COMMENT RESOLUTION FORM

Date:	6/1/2022	Disposition Codes:	
FHU Project Number	117253-08 EPC Reviews 2022	A. Accept Comment	E. Comment Conflicts with Previous Direction
Project Name:	Sterling Ranch Road over Sand Creek Bridge	B. Delete Comment	F. Designer to Evaluate Comment
Project Number:		C. Clarify Comment	G. Discuss Comment; Follow-up Required
Client:	El Paso County	D. Disagree with Comment	
Designer:	Contech Engineered Solutions; KBJW		
Submittal:	Review 1	Other Review:	N/A

PROJECT No. 705931	SEQ. No. 010	DATE 4/6/2022
DESIGNED: XXX	DRAWN SCC	
CHECKED: EDE	APPROVED: XXX	
SHEET NO.: 2 OF 7

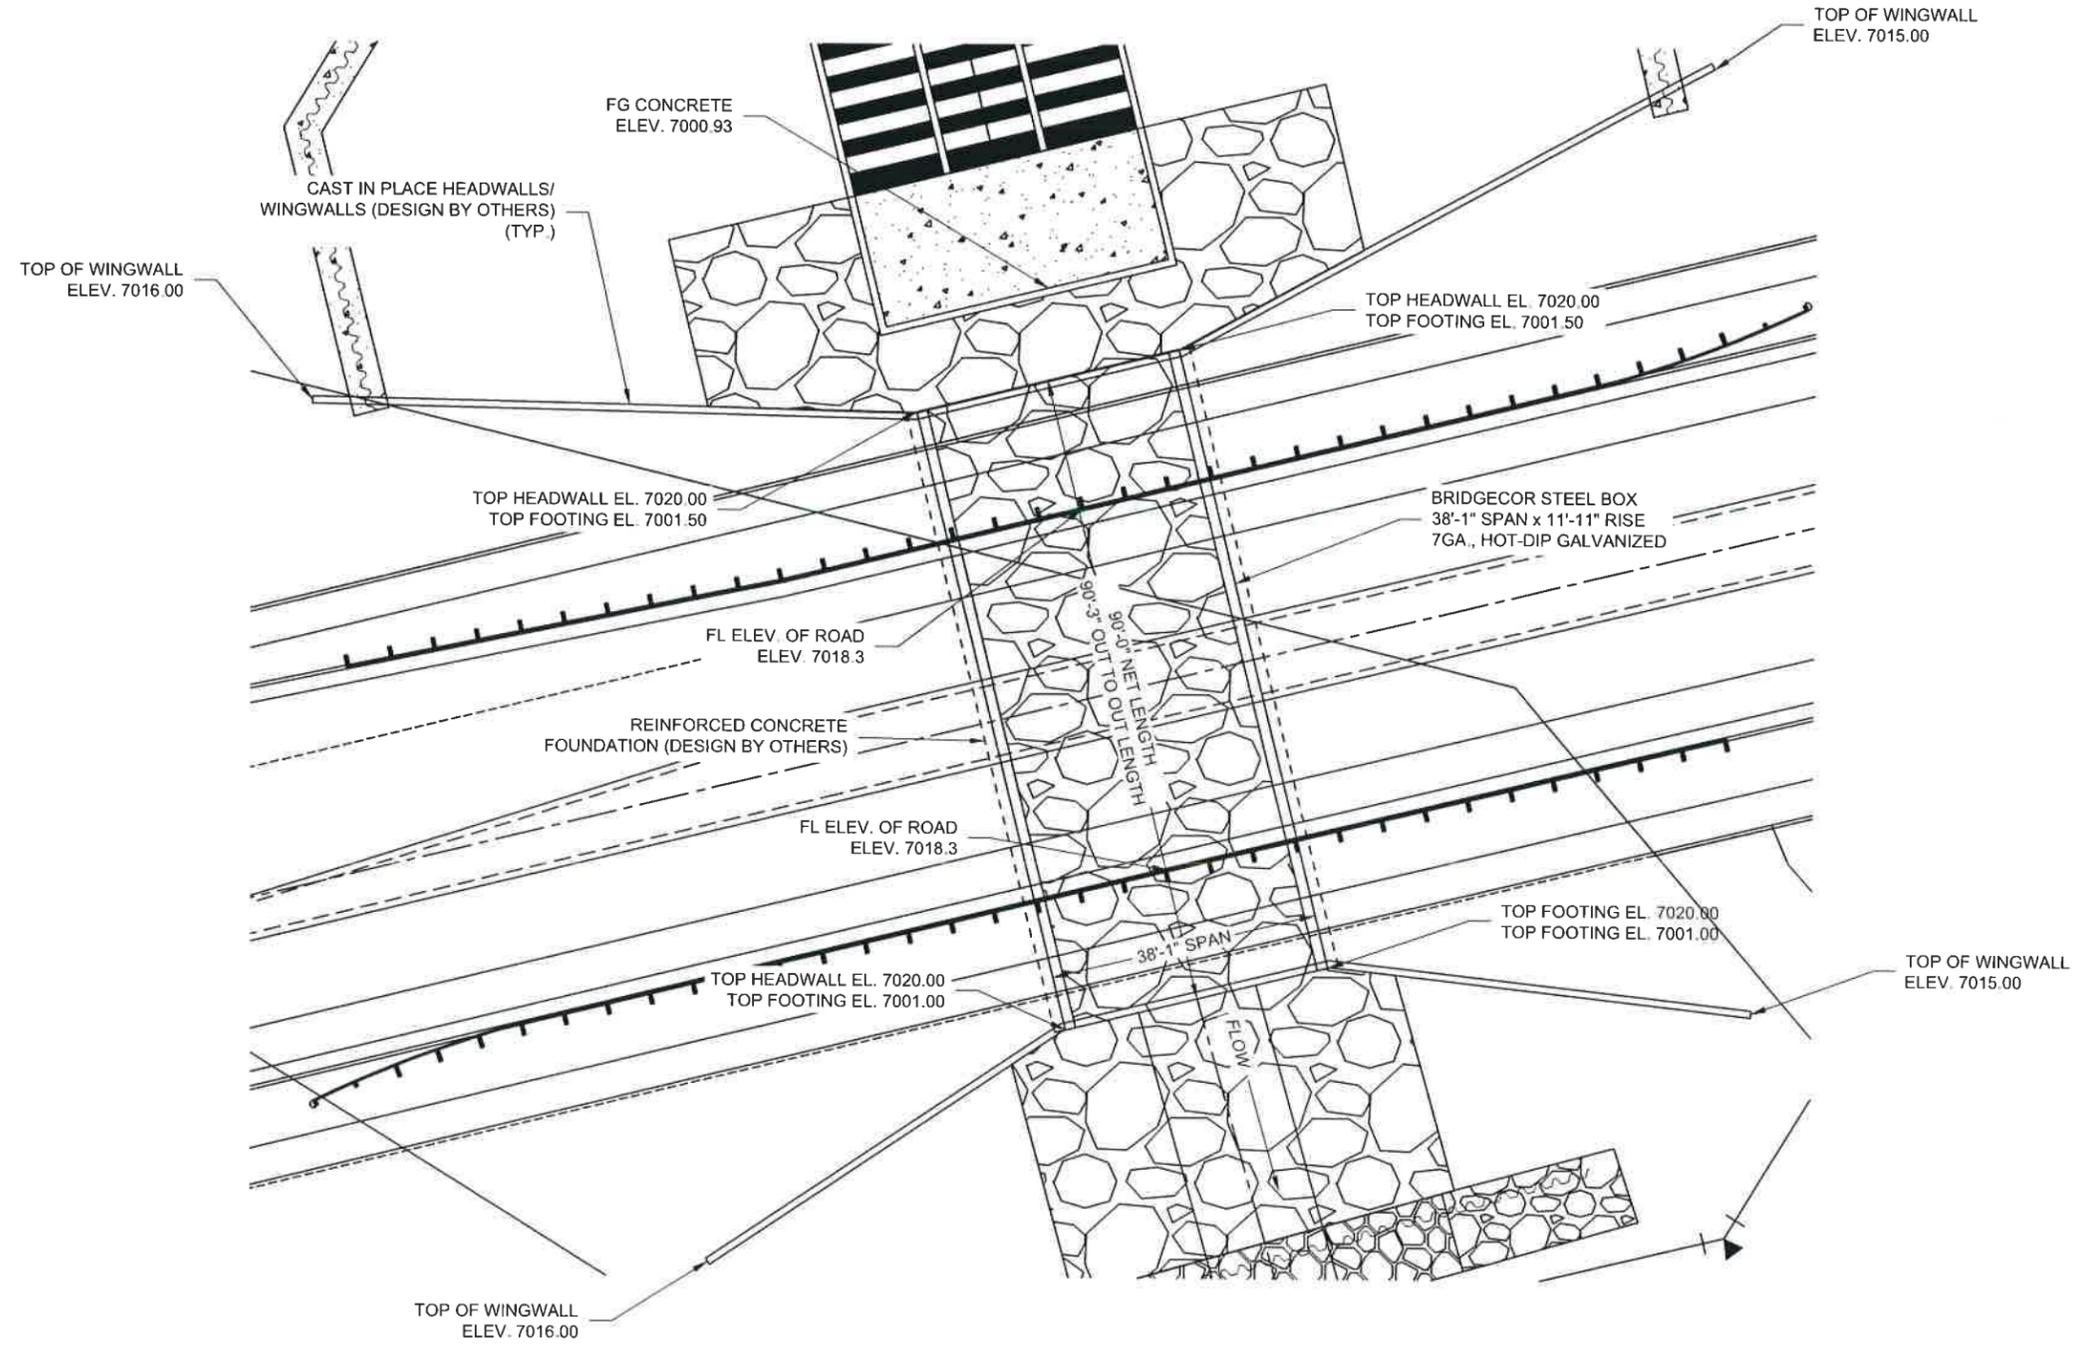
Reviewer Comments				Designer/Consultant Response			Final Disposition		
Comment No.	Reviewer	Sheet/ Page No.	Comments	Initial Code	Date	Response	Code	Date	Initials
1	CAO	CONTECH plan sheet 3 of 7	Headwall						
2	CAO	General calculations, CONTECH plan sheet 6 of 7	Confirm fill does not exceed 5'-0" per design. It is unclear from the Grading and headwall plans what the maximum fill height will be.		7/15/22	Please see revised plans and report for better defined fill height over structure. Planned fill height min. is 5.1' and a max. of 5.75' per the revised report.			
3	CAO	KBJW plan sheets 3, 4	An indication of FG height below TOW at BF would be helpful in this section.		7/15/22	Dimension now added to sections			
4	CAO	KBJW Bridge Design Report pg 1	Addendum table with updated bearing capacities not provided for review. The referenced Entech Engineering report for Job No. 211647 for Briargate Parkway over Sand Creek does not indicate the bearing pressure noted here. Please provide addendum/report for verification.		7/15/22	Geotech. Addendum previously provided to Jeff Rice directly
